February 12, 2024

Subject: **Turlington Subdivision Flexible Development Standards**

FOUNDATION SURVEY

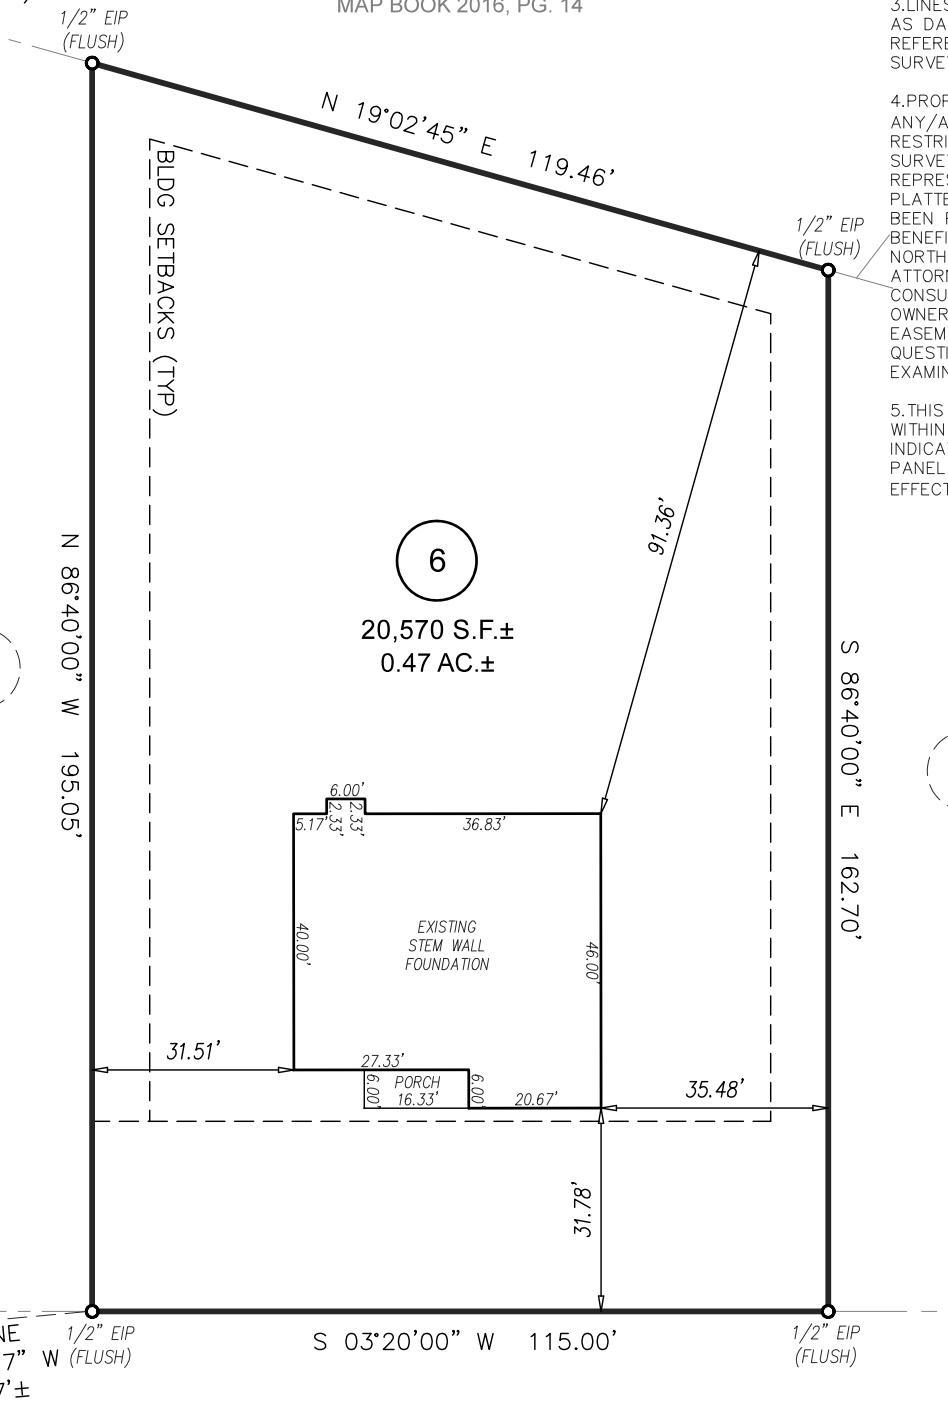
Because these are lots of record, established long before the July, 2022 adoption of the UDO, they will be allowed to comply with the Article 14.3-1 flexible development standards. The 1' encroachment into the front setback falls within the 10% allowance.
